Table 1 – Department of Planning and Infrastructure

Table 2 – City of Sydney

25 JULY '13
SCALE 1:200 @ A3
12S9018000-03-02-P3

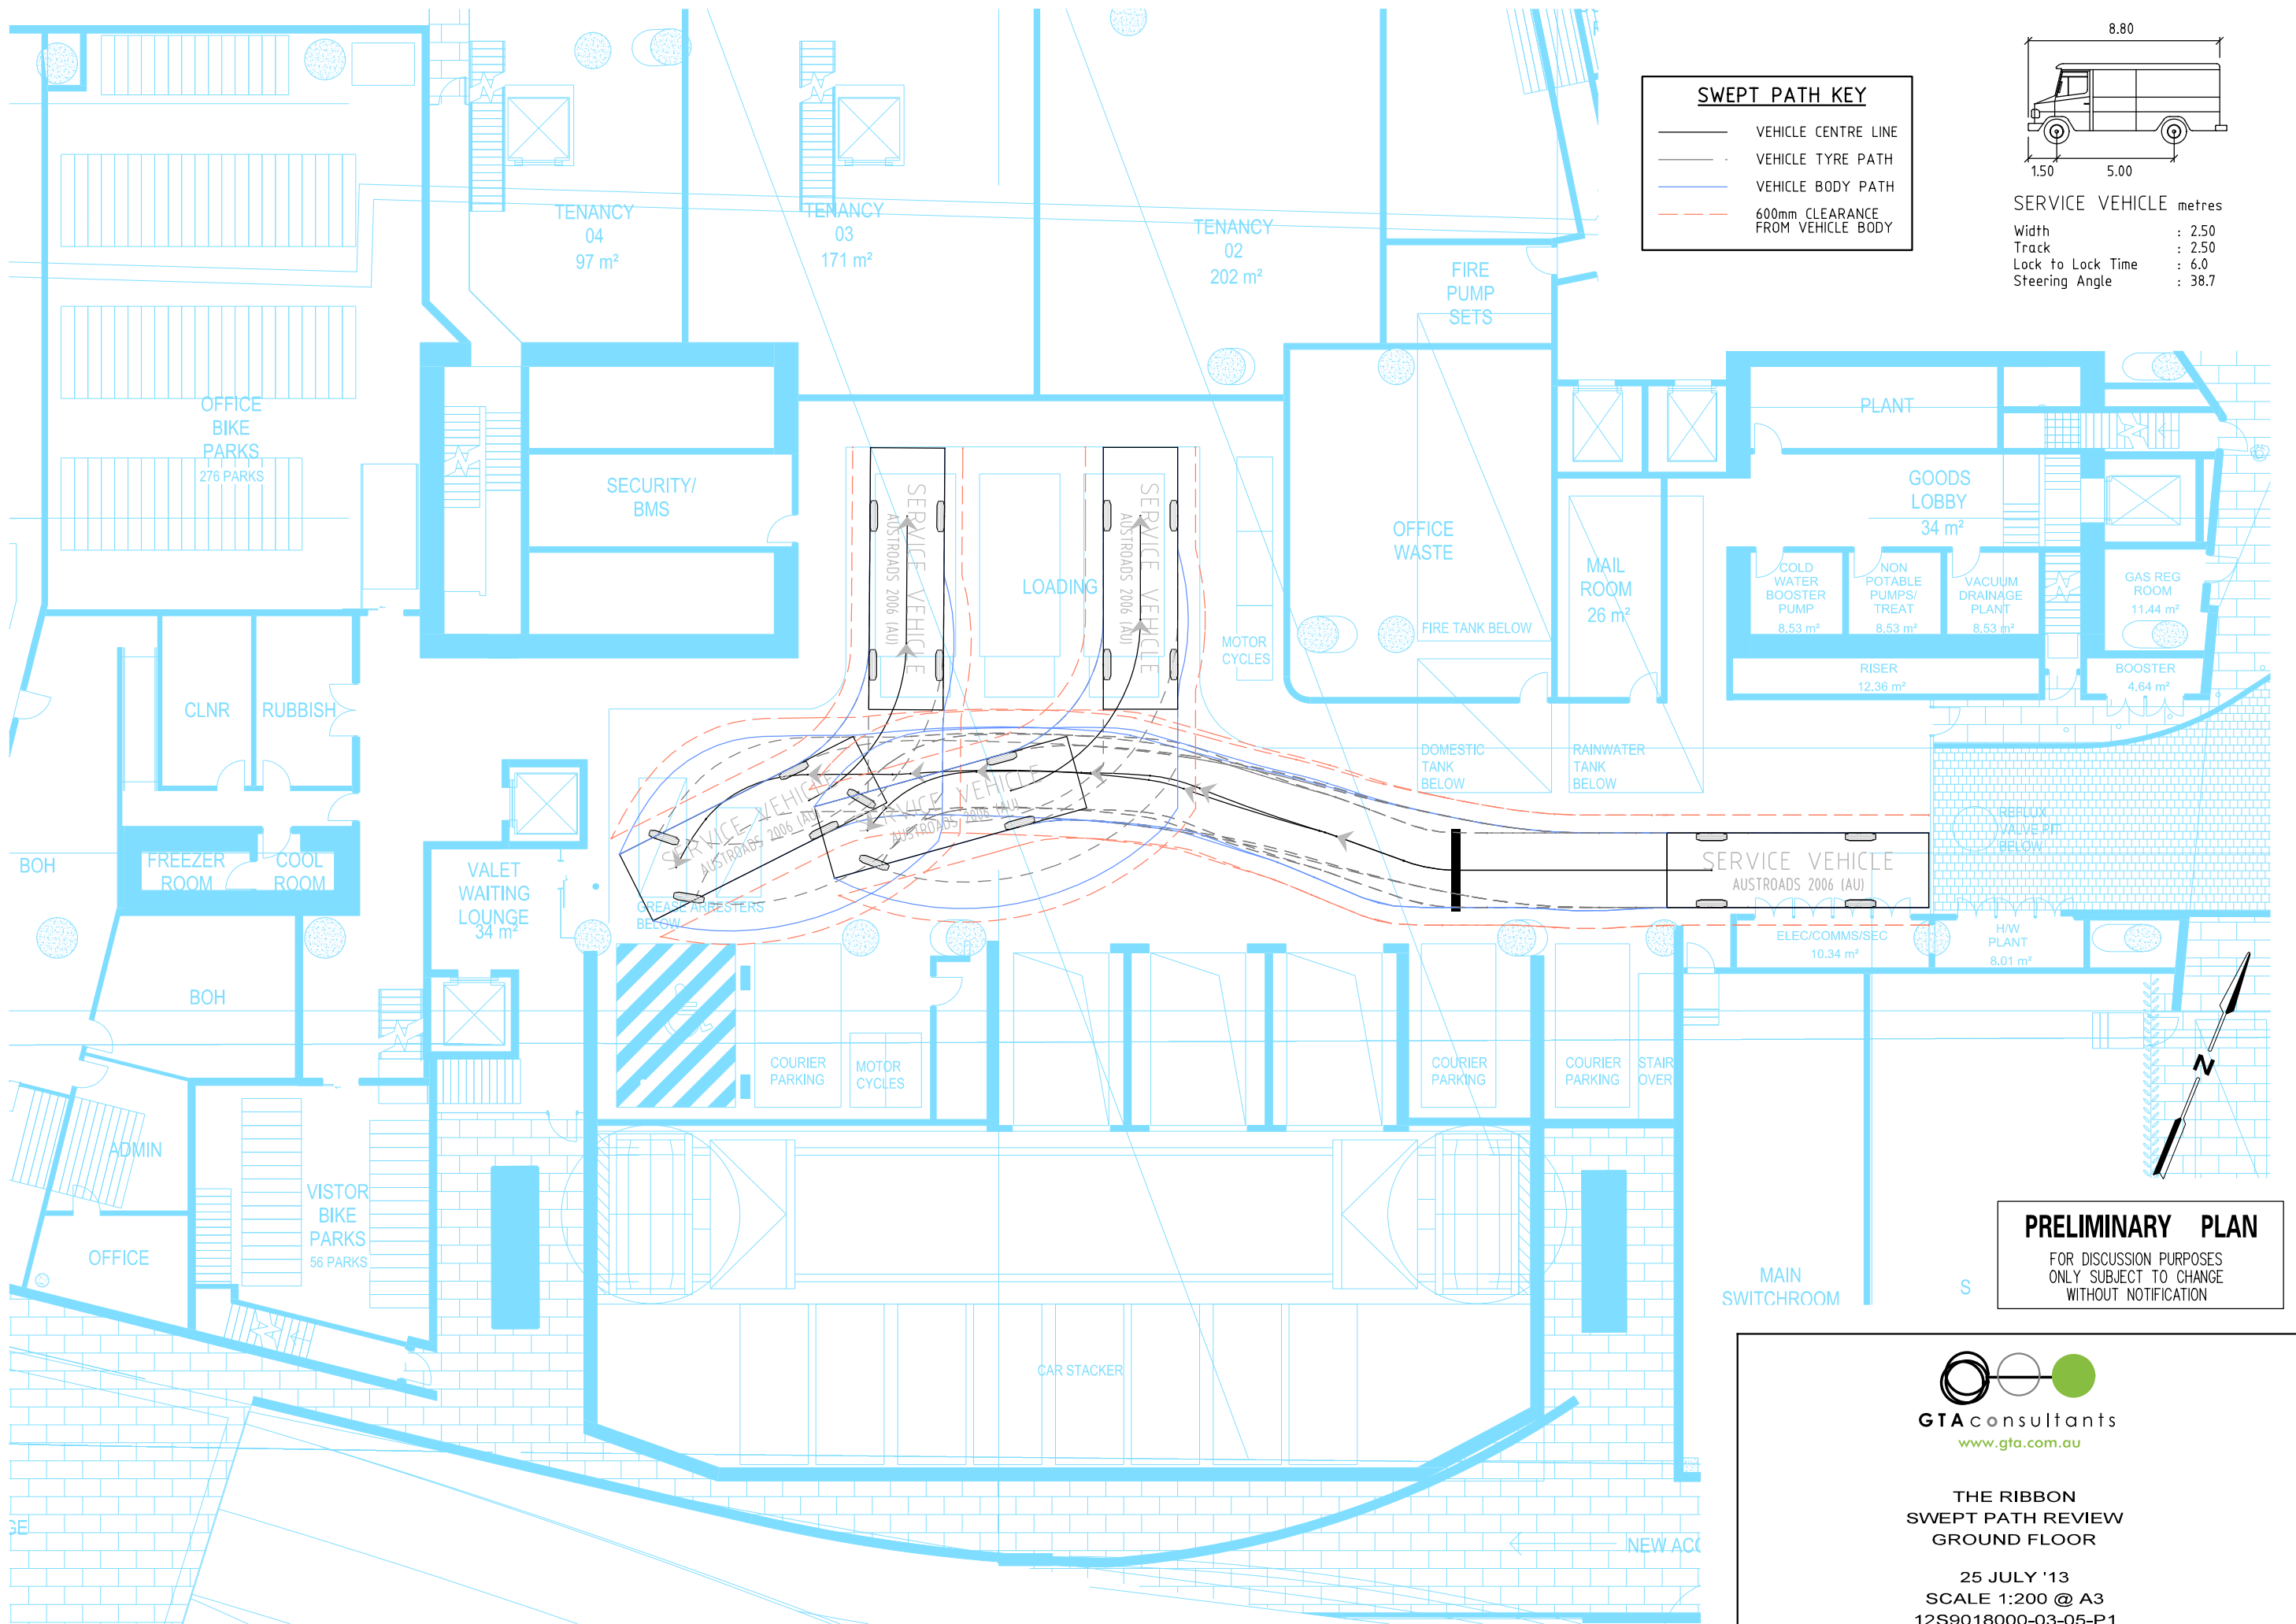
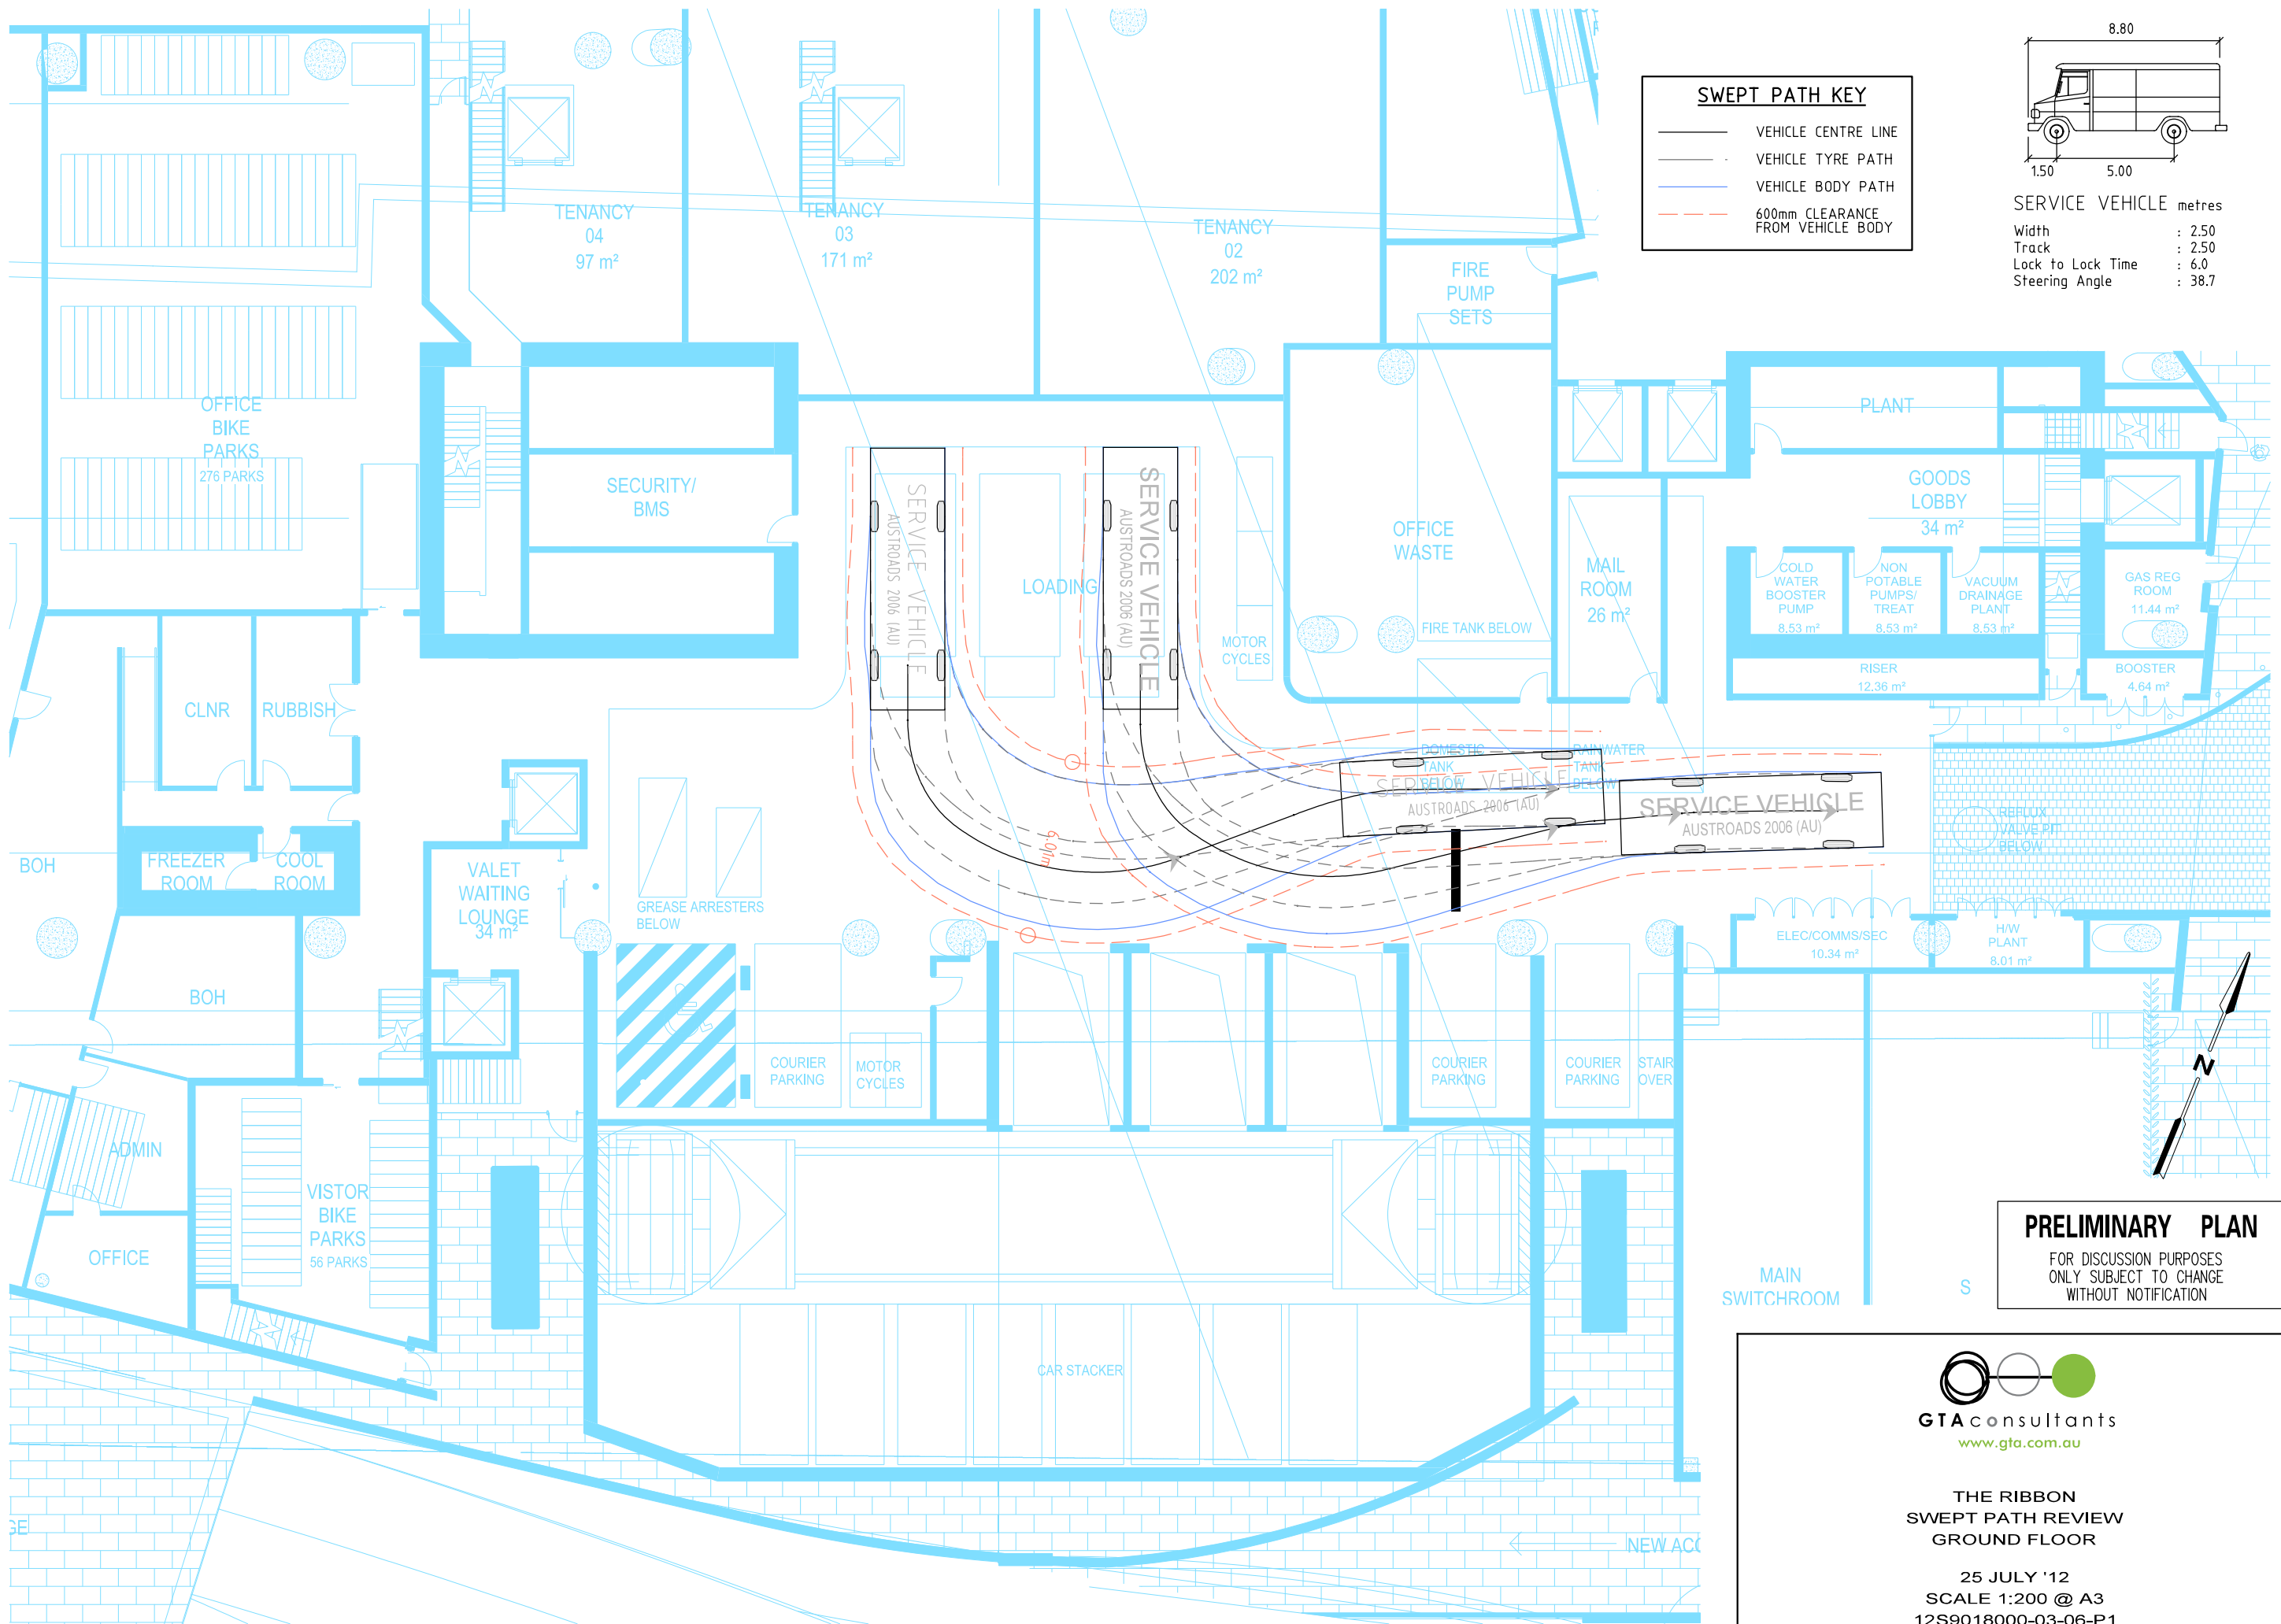
Category	Recommendation/issue	Comment
	A minimum path width of 1.6m is to be maintained within the loading area. In particular, the pinch point on the eastern corner of the hydrant booster (at the entrance to the loading zone) should be rectified.	Within the loading area a shared zone is to be linemarked and be at least 16m wide. A 1.2m zone will be provided at the 'pinch point' of the eastern corner.
	A Green Travel Plan and transport access guide should be prepared prior to the occupation of the building.	A Green Travel Plan was a recommendation of the Transport Impact Assessment originally submitted, and will be prepared prior to the occupation of the building.
Heritage	<p>A complete Heritage Impact Statement should be prepared for the proposal. This should consider a larger catchment of heritage assets, including those in the western CBD, Pyrmont peninsula, and Darling Harbour.</p> <p>The Heritage Impact Statement should discuss resultant loss of heritage character and setting for heritage items and special character areas within the City of Sydney as a result of the visual impacts of the proposal.</p> <p>Section drawings should be provided to demonstrate the impact of the proposal on Sewage Pumping Station No. 12 and other heritage assets.</p> <p>The Heritage Impact Statement should assess the impacts on important views from Sydney Harbour in respect of the Sydney Regional Environmental Plan (Sydney Harbour Catchment) 2005, specifically Section 25 Foreshore and Waterways Scenic Quality that requires certain matters to be taken into consideration in relation to the maintenance, protection and enhancement of the scenic quality of foreshores and waterways.</p> <p>The Heritage Impact Statement should assess how the bulk and scale of the proposal maintains visual connectivity between the western precinct of the CBD and Darling Harbour, the Pyrmont Peninsula, and Pyrmont Bridge.</p> <p>The Heritage Impact Statement should assess the geographic connectivity between heritage items in the harbour and between the CBD and Pyrmont Peninsula.</p> <p>The Heritage Impact Statement should demonstrate how the proposal interprets the natural and cultural heritage of the area</p> <p>Any proposed relocation of the Carousel and Organ should be preceded by a thorough planning exercise developed in accordance with the policies and procedures outlined in the Conservation Management Plan for these items (SHFA 2012).</p>	Refer Section 2.5.2 of Response to Submissions.
